Consultation Response from Emma Mills
KC Landscape

Application No:	2022/92194
Proposed Development:	Outline application for erection of care home (Use Class C2) of up to 60 beds with associated access
Location:	Land adj, 21, Thomas Street, Lindley, Huddersfield, HD3 3JJ
Applicant/Agent:	Walsingham Planning
Planning Officer	Malachy McGovern
Date Responded:	09/08/2022
Responding Officer:	HP
Responding Ref:	LL50

Figure 2: Proposed Site Plan (ADG Architects, 2022)

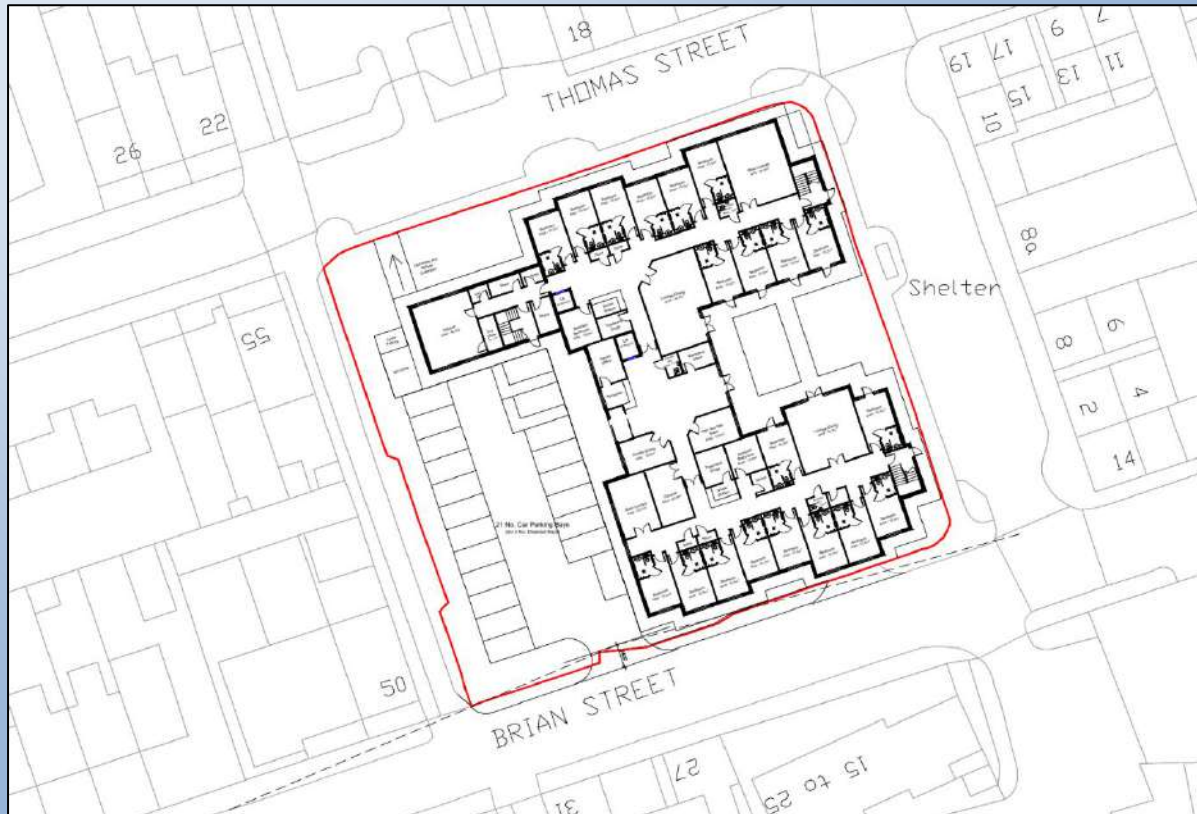
Some of the green areas indicated on the Proposed Site Plan (drawing (9-2)) appear very narrow, particularly between the North Wing and Thorncliffe Street. Sufficient space to allow for planting should be considered.
